**Comments on the Applicant's Responses
to the Examining Authority's
First Written Questions**

**for the
Royal Society for the Protection of Birds
and Suffolk Wildlife Trust**

**Submitted for Deadline 3
24 June 2021**

**Application by NNB Generation Company (SZC) Limited for an Order
Granting Development Consent for
The Sizewell C Project**

**PLAN**  
 SCALE 1:500

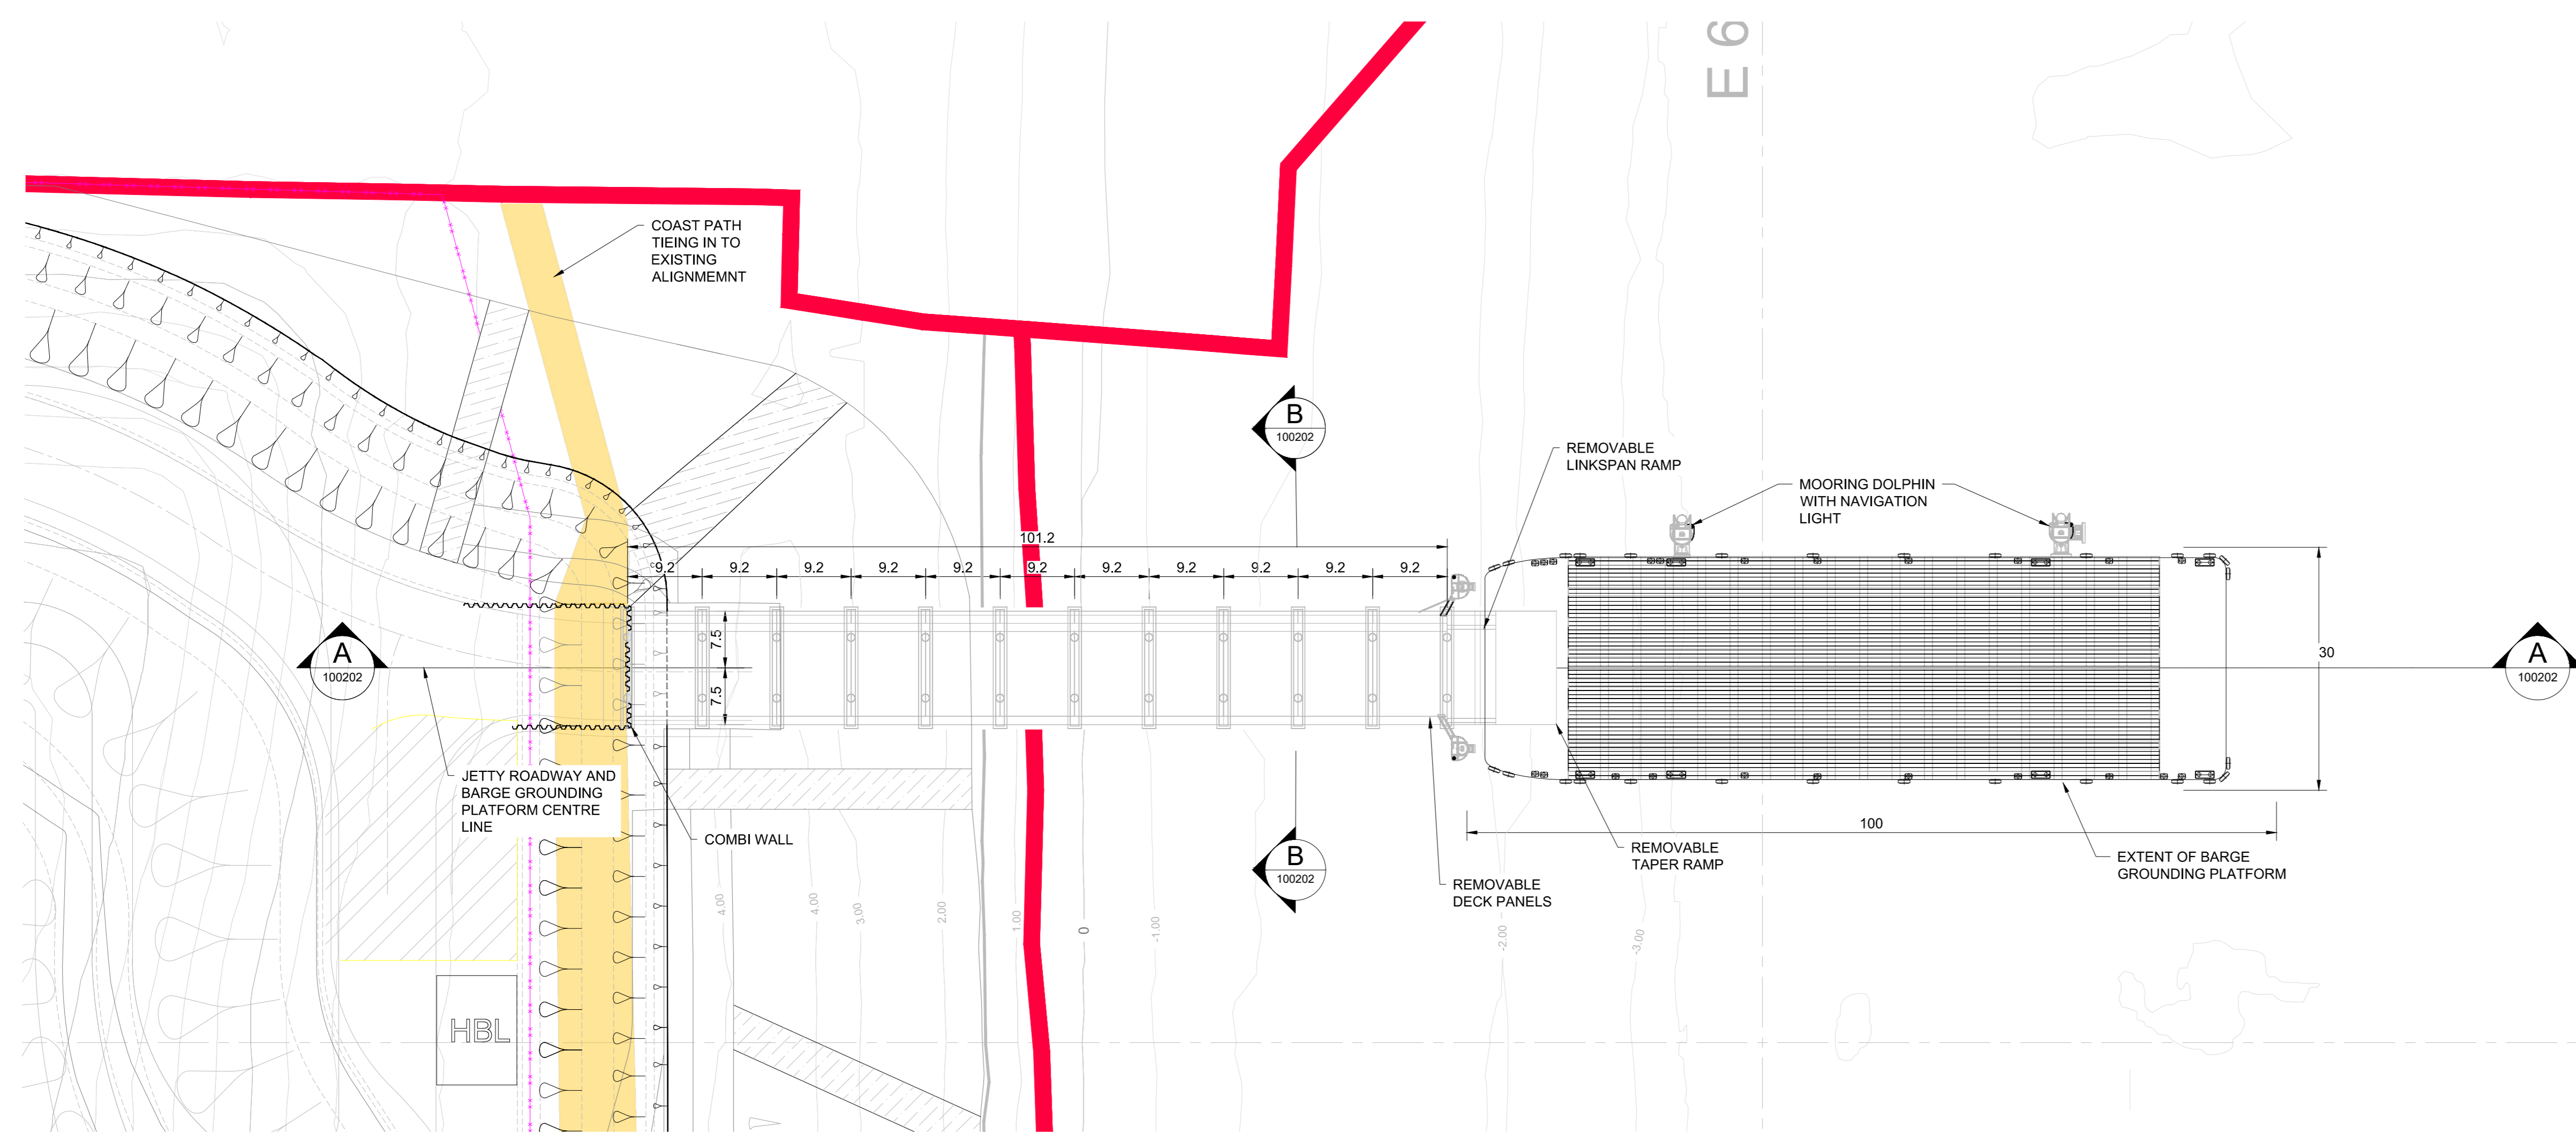
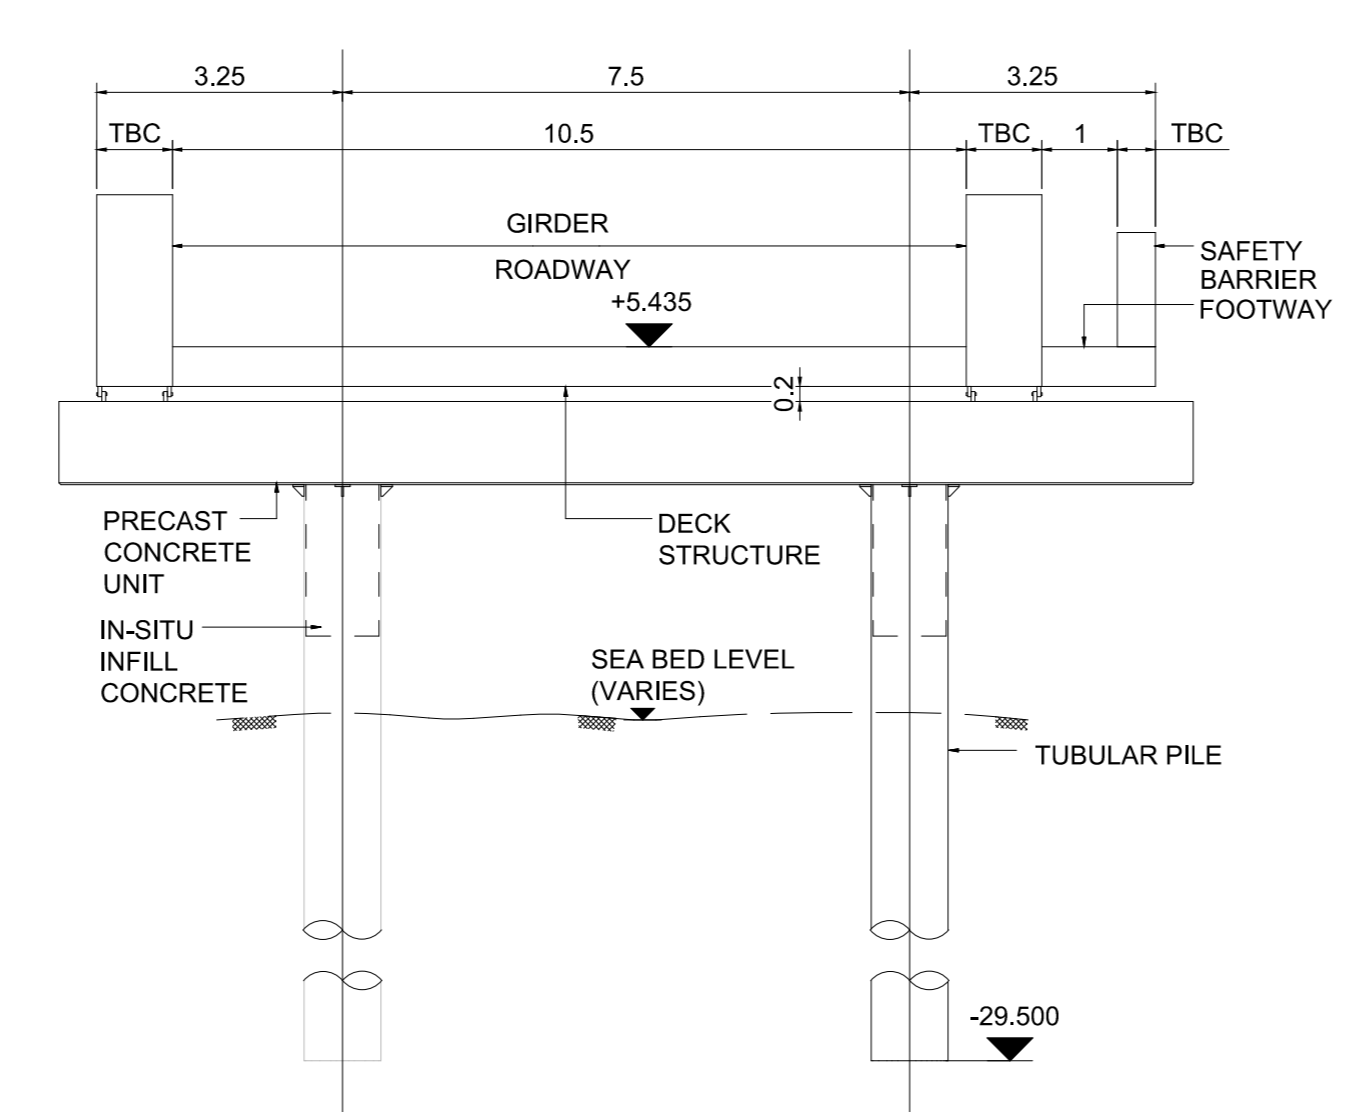
Bio.1.47	[APP-224] – para 14.4.10 bullet 5 – primary mitigation, the SSSI crossing. Please will the Applicant submit a set of drawings showing the location, plan, elevations, sections and design of the SSSI crossing , together with the context,	A full set of drawings relating to the current single span bridge proposals included in the Accepted Changes (April 2021) [PDA-004 and PDA-005] were submitted in response to the Rule 17 letter of 25 February 2021 [PD-012]. However, as stated in the answer to Question G.1.32 in Chapter 2 (Part 1) of this report, in response to feedback from stakeholders following the Accepted Changes (April 2021), a design review was commissioned to determine if the structure could be optimised to further reduce impacts on Sizewell Marshes SSSI. In response to ecological concerns raised by	We welcome the proposal to reduce the width of the bridge to approximately 15m once the power station has been built. However, we note that the Applicant proposes to submit updated indicative plans and further details at Deadline 4. We are concerned that only indicative plans will be submitted at Deadline 5 and without full details

Question ref.	Question	Applicant's response	Comments from RSPB and Suffolk Wildlife Trust
	<p>ecological and landscape. It is appreciated that the design is a work in progress, but the location, plan, elevations and sections of what is proposed should be capable of being fixed now. If this has been done further to the Rule 17 letter of 25 February 2021 [PD-012] there is no need to duplicate the material. Please however submit any material not sent in response to [PD-012] and also state the Examination Library reference(s) for the material which was submitted.</p>	<p>stakeholders, SZC Co. has further optimised the design and proposes to reduce the width of the bridge to approximately 15m once the power station has been built. This would be achieved by removing part of the bridge deck. It is also proposed to raise the soffit level of the bridge in response to stakeholder feedback. Updated indicative plans and further details will be submitted at Deadline 4. Requirement 12C of the draft DCO will be updated at the same time to secure primary mitigation. Appendix 7E of this chapter provides three figures which provide the ecological context to the location of the crossing. A new set of figures will be provided for Deadline 4 to align with updated design details referred to above.</p>	<p>potential impacts cannot be adequately considered and assessed.</p> <p>We also highlight that Deadline 5 is after the biodiversity ISHs on 15 and 16 July where this issue may arise. We therefore request detailed plans are submitted to the Examination at the earliest opportunity and if possible before the ISH, with adequate time for parties to consider.</p>
